CITY OF ALBUQUERQUE

**RE: Bosque Plaza – Guardian Storage
Conceptual Grading and Drainage Plan
Stamp Date: 6/5/17
Hydrology File: E12D006E**

Based upon the information provided in your submittal received 9/13/2017, the Conceptual Grading and Drainage Plan **is not** approved for Site Plan for Building Permit. The following comments need to be addressed for approval of the above referenced project:

| GUARDIAN STORAGE GRADING & DRAINAGE PLAN | |

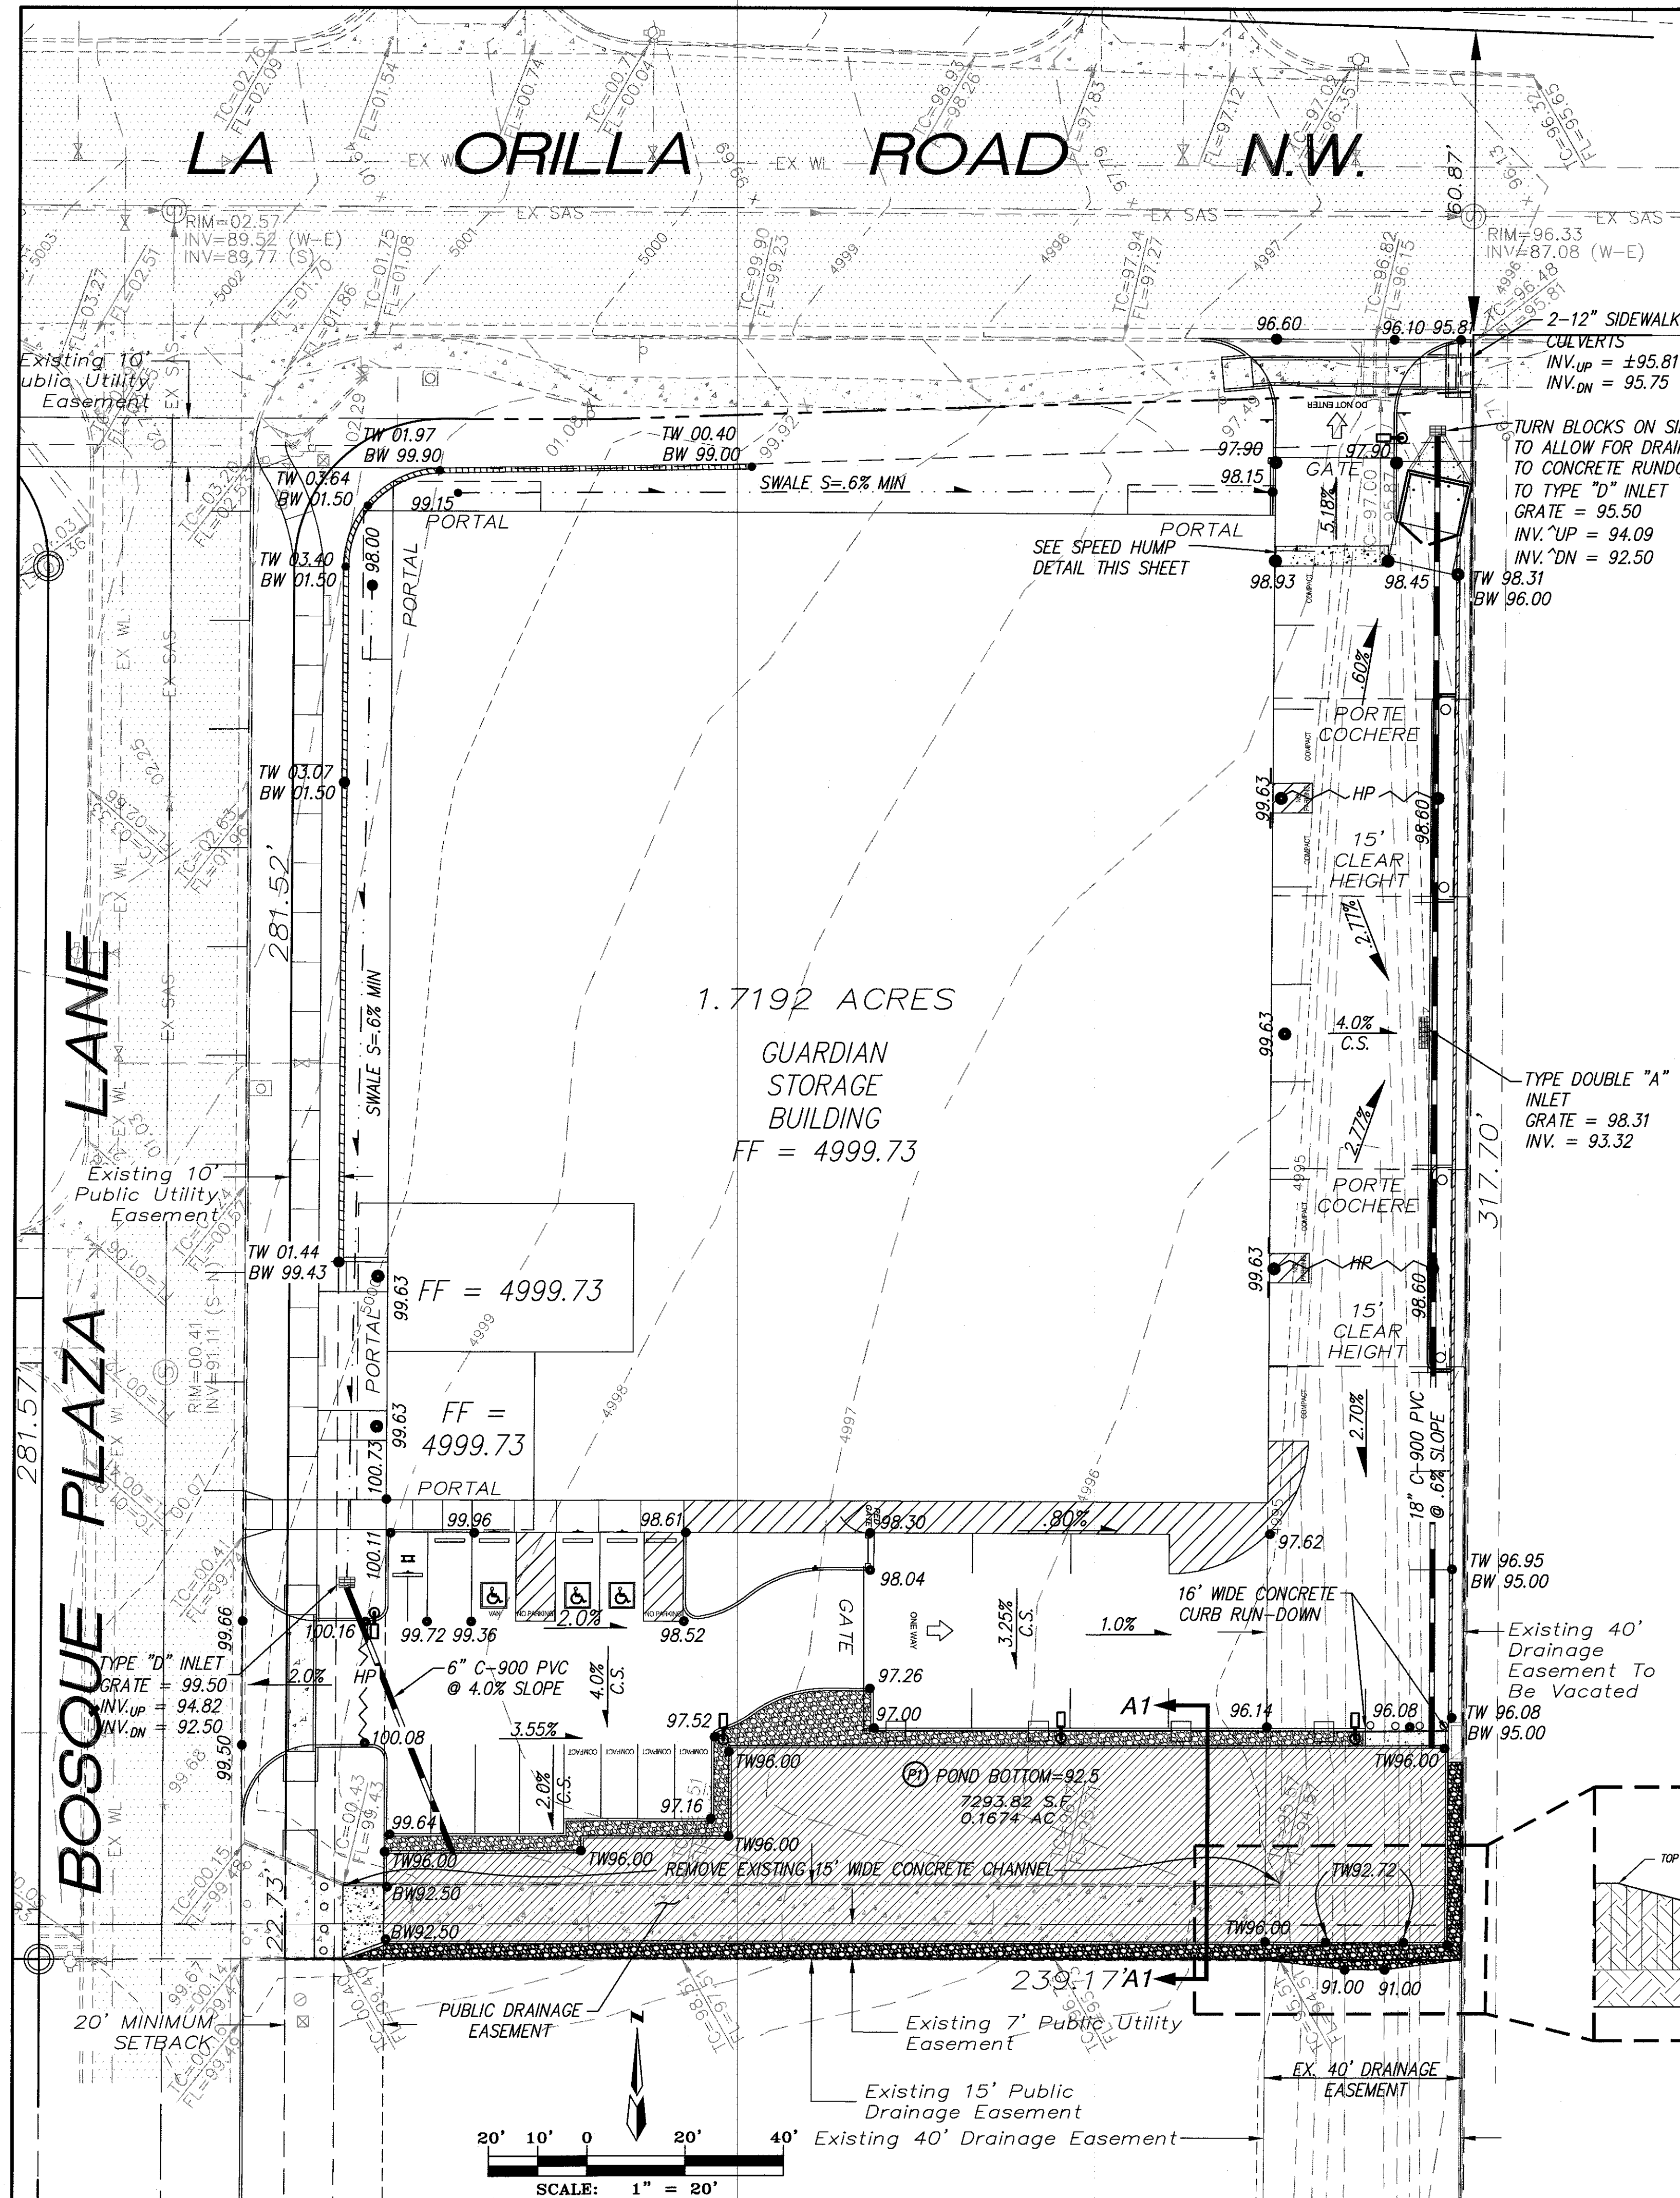
1. The site currently shows more than 1 acre of disturbance is being proposed. An Erosion and Sediment Control Plan is required and has to be submitted to the storm water quality engineer (Curtis Cherne, PE, ccherne@cabq.gov). Hydrology's approval for Grading or Building Permit will not be given until the submittal of the ESC Plan.
2. Please add the word "Conceptual" to the sheets title and add a note stating "Not for Construction".
3. Please relocate both the north arrow and scale so that it does not interfere with the Grading and Drainage plan.
4. Please provide the legal description of the property.
5. Please provide the flood plain note with effective date.
6. Please provide the benchmark information for the survey contour information provided.

7. This site is part of a Master Drainage Report for Bosque Plaza prepared by Tierra West with engineer's stamp date of 9/25/2002. Please add this information to the site's drainage narrative.

8. Please add the note, "Lot 1 is subject to all restrictions, conditions, and requirements as set forth in that certain "Bosque Plaza Declaration of Easements, Covenants, and Restrictions", filed in the office of the County Clerk of Bernalillo County, New Mexico on the 28th day of July, 2004 in Book A81, Page 5448."

9. Please label all existing drainage easements on the property.
10. Please identify the upstream and downstream hydraulic constraints affection the property.

11. There is an existing 40 feet drainage easement along the east property line. This project is proposing to fill in the existing public drainage ditch/pond. Also this project is proposing to remove the existing two sidewalk culverts at the location of the proposed driveway. These sidewalk culverts collect the drainage from the public Right-of-Way of La Orilla Road NW. Both of these actions will not be allowed unless the proper evaluation of the existing public watershed for the existing public drainage ditch/pond is done with provided calculations and an alternate underground drainage structure with a storm inlet within the public Right-of-Way of La Orilla Road NW.

12. Please show the 4 inch force main is shown on the Grading and Drainage Plan. Especially where it will outfall. Please also show a cross section of the force main from the pump to the outfall.

(A1) TYPICAL CROSS SECTION FOR FIRST FLUSH PONDING

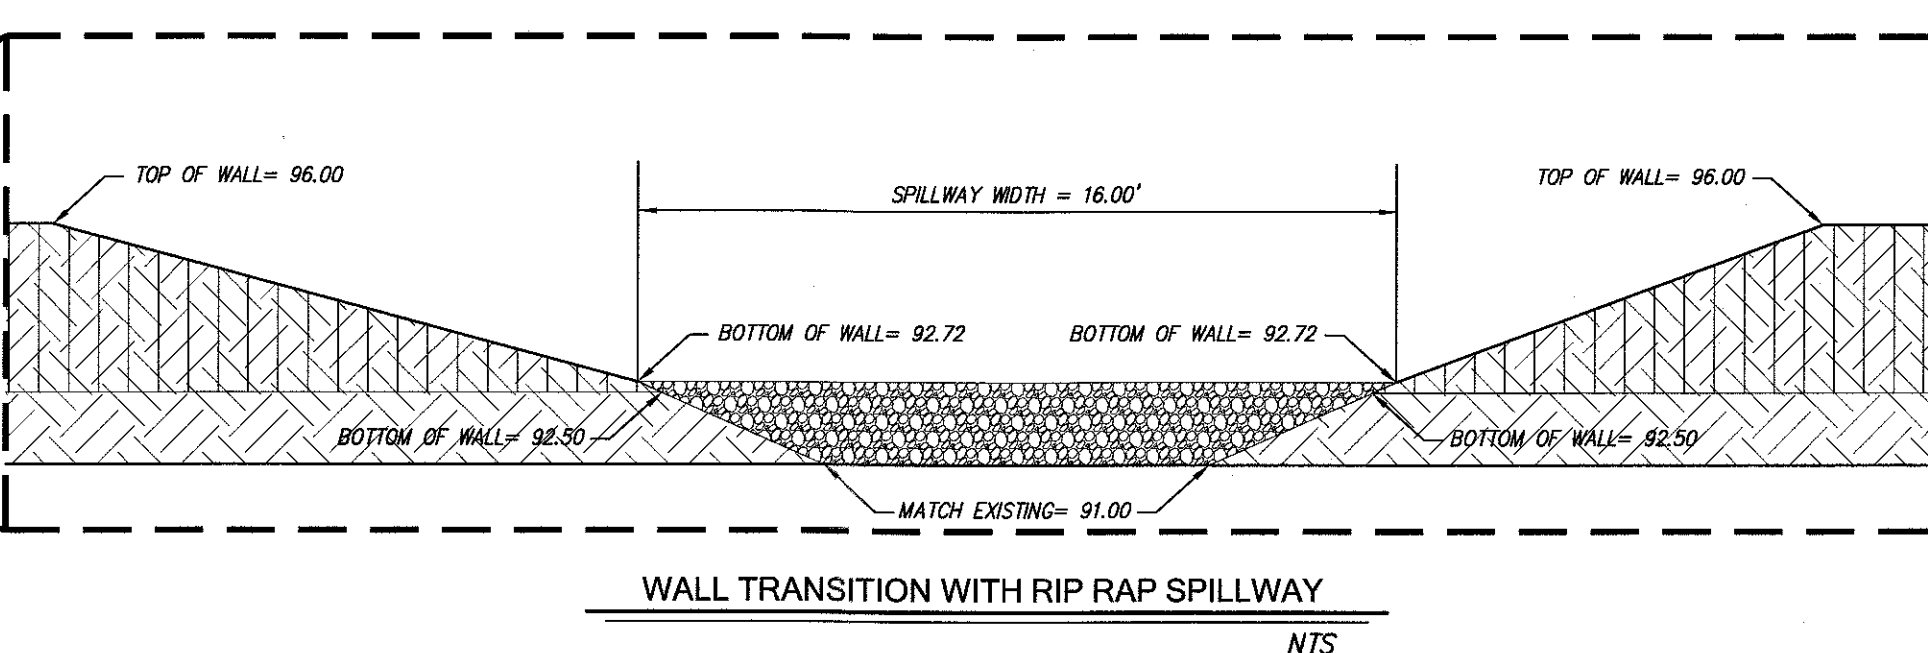
13. The Typical Cross Section of the First Flush Pond. Please add the property line and the existing 15 feet drainage easement.
14. The Storm Sewer Lift Station. Please provide both the elevation of the top and bottom of lift station.
